#### Engineers Comments Regarding Surface Water Drainage

**Application No:** BN/151/20/PL  
**Registered:** 14th December 2020  
**Site Address:** Land at rear of Poachers Eastergate Lane Eastergate PO20 3SJ  
**Grid Reference:** 494870 106097  
**Description of Works:** Erection of 1 No. 4 bedroom detached dwelling with detached carport (resubmission following BN/46/20/PL). This site is in CIL Zone 3 & is CIL Liable as new dwelling & is a Departure from the Development Plan.

20-038/DL1

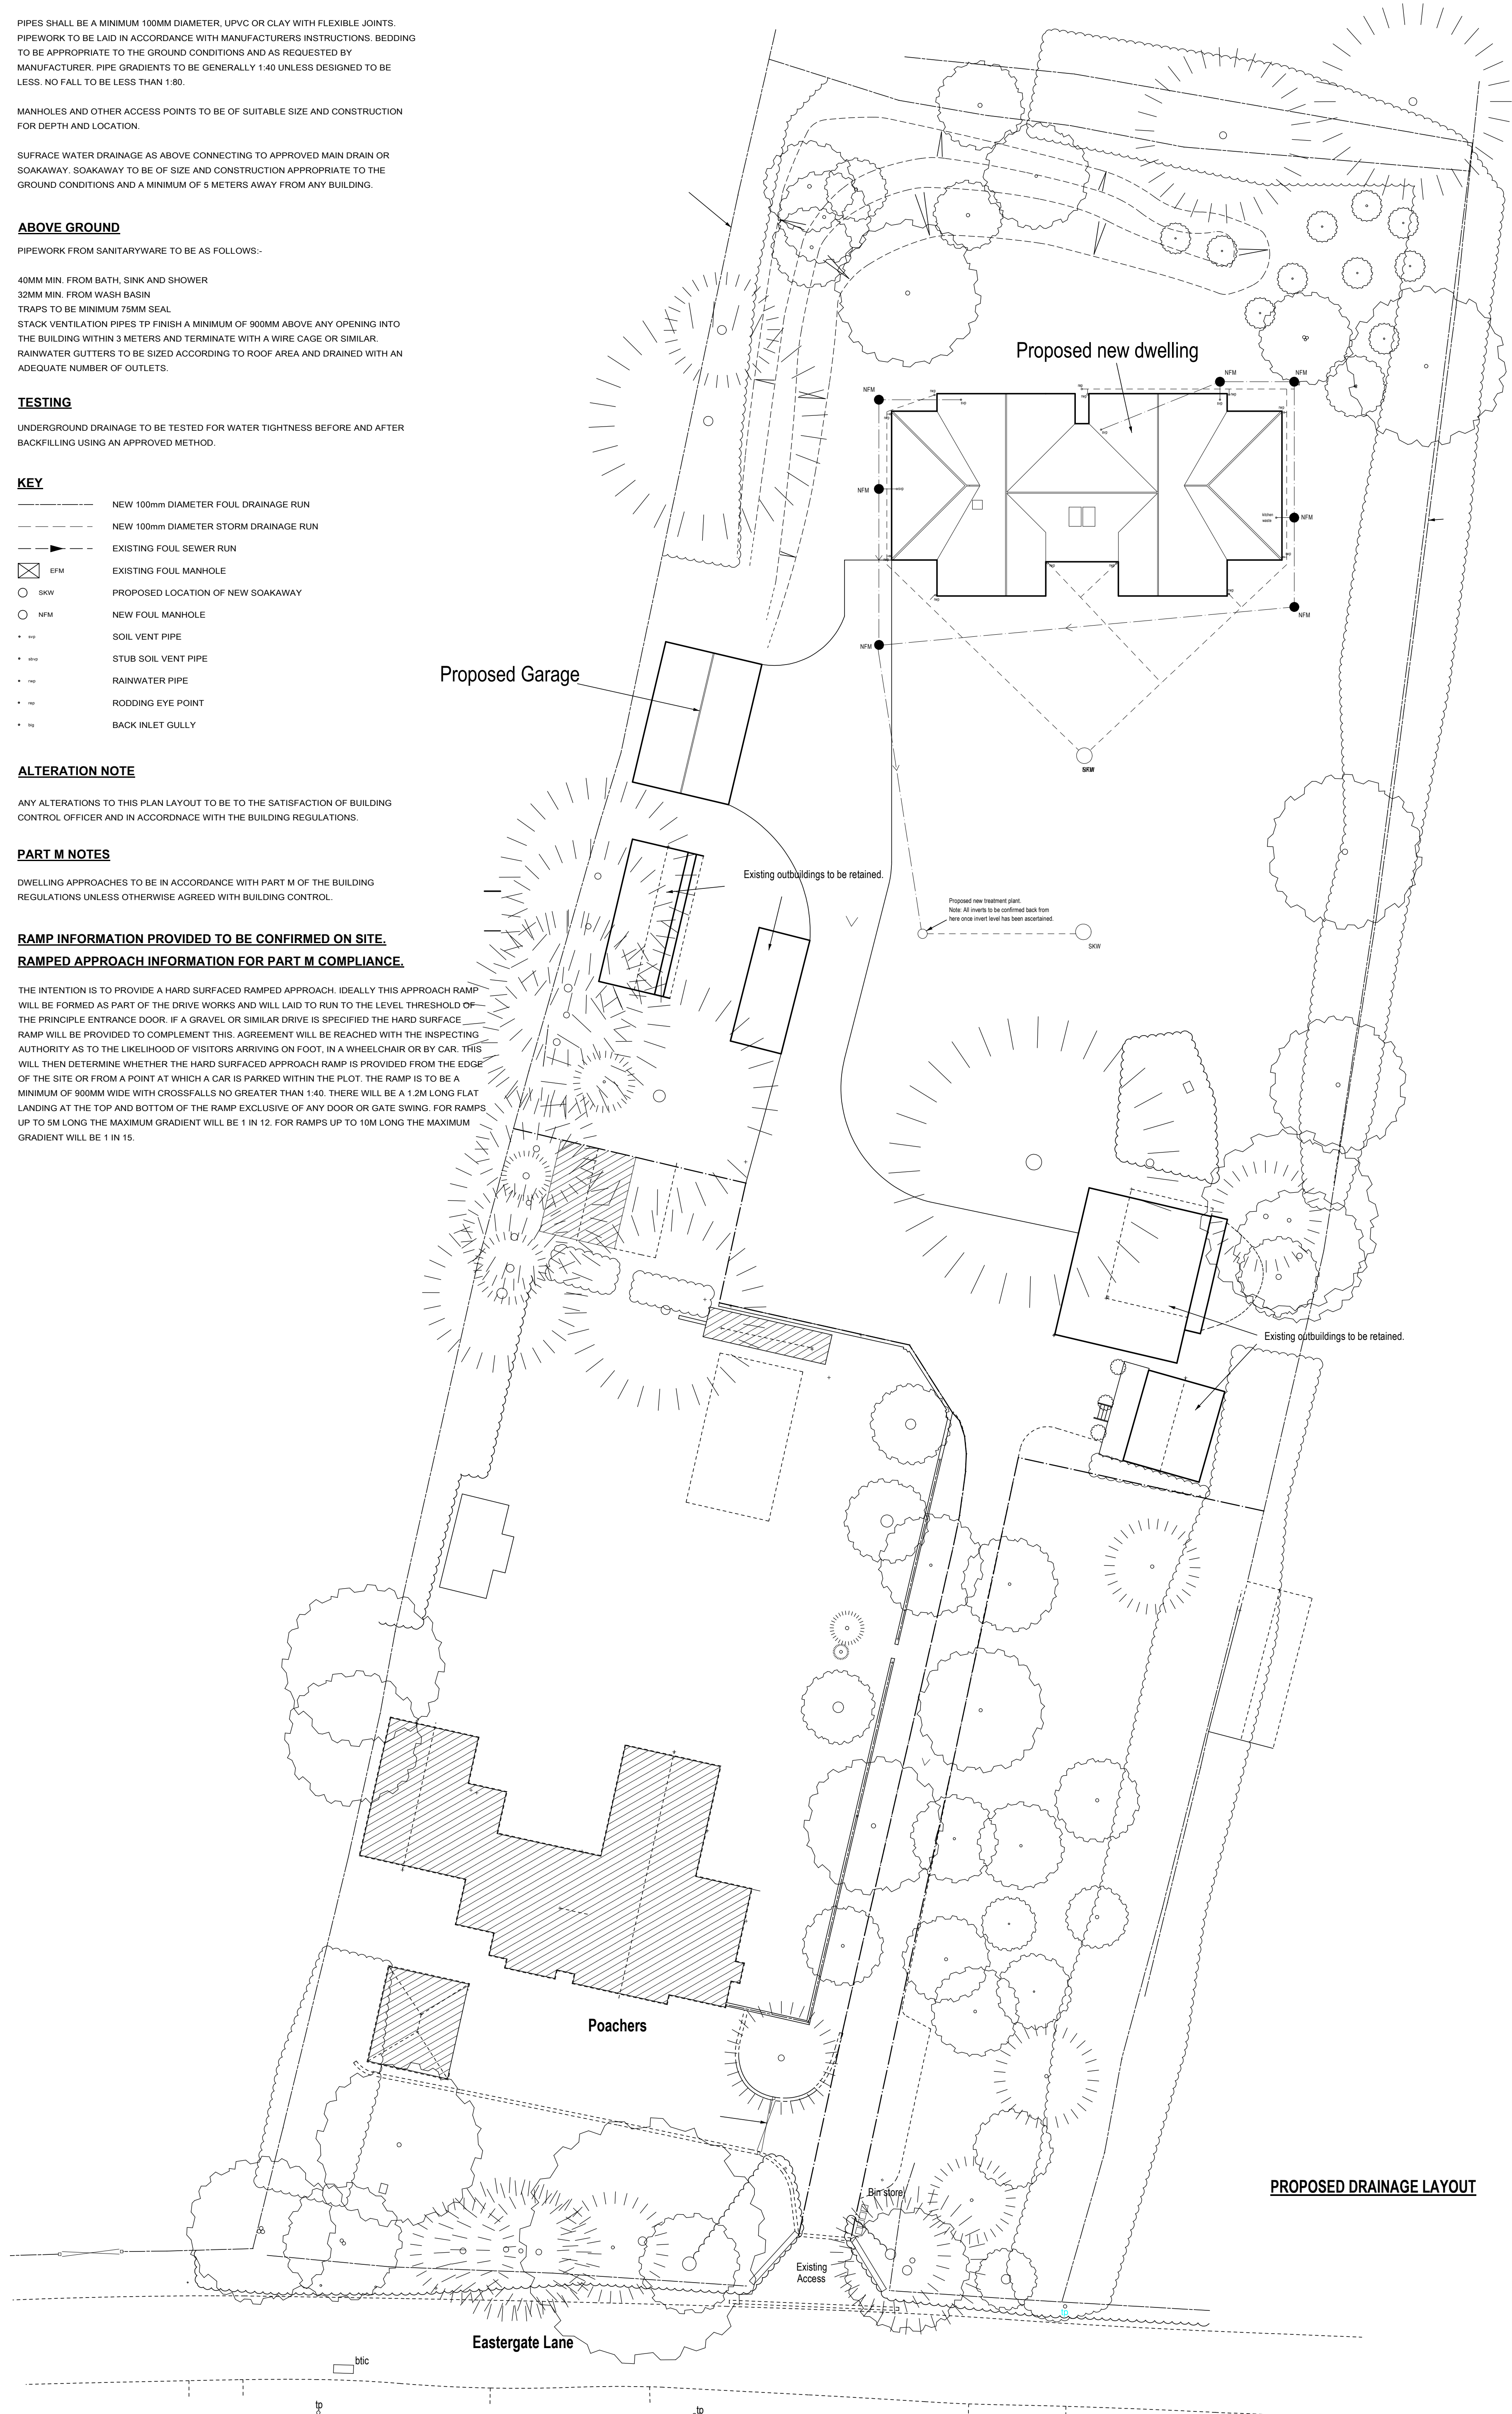
The application is within the Lidsey Treatment Catchment, therefore surface water drainage design should be carefully considered. Infiltration must be fully investigated. A General Drainage Specifications/Layout has been provided, however it appears that no infiltration testing or groundwater monitoring has been undertaken to inform the detailed design. No detailed design, calculations or construction details have been supplied at this stage.

*"Development shall not commence, other than works of site survey and investigation, until full details of the proposed surface water drainage scheme have been submitted to and approved in writing by the Local Planning Authority. The design should follow the hierarchy of preference for different types of surface water drainage disposal systems as set out in Approved Document H of the Building Regulations, and the recommendations of the SuDS Manual produced by CIRIA. Winter groundwater monitoring to establish highest annual ground water levels and winter Percolation testing to BRE 365, or similar approved, will be required to support the design of any Infiltration drainage. No building / No part of the extended building shall be occupied until the complete surface water drainage*

system serving the property has been implemented in accordance with the agreed details and the details so agreed shall be maintained in good working order in perpetuity."

*"Infiltration rates for soakage structures are to be based on percolation tests undertaken in the winter period and at the location and depth of the proposed structures. The percolation tests must be carried out in accordance with BRE365, CIRIA R156 or a similar approved method and cater for the 1 in 10 year storm between the invert of the entry pipe to the soakaway, and the base of the structure. It must also have provision to ensure that there is capacity in the system to contain below ground level the 1 in 100 year event plus 40% on stored volumes, as an allowance for climate change. Adequate freeboard must be provided between the base of the soakaway structure and the highest recorded annual groundwater level identified in that location. Any SuDS or soakaway design must include adequate groundwater monitoring data to determine the highest winter groundwater table in support of the design. The applicant is advised to discuss the extent of groundwater monitoring with the Council's Engineers.*
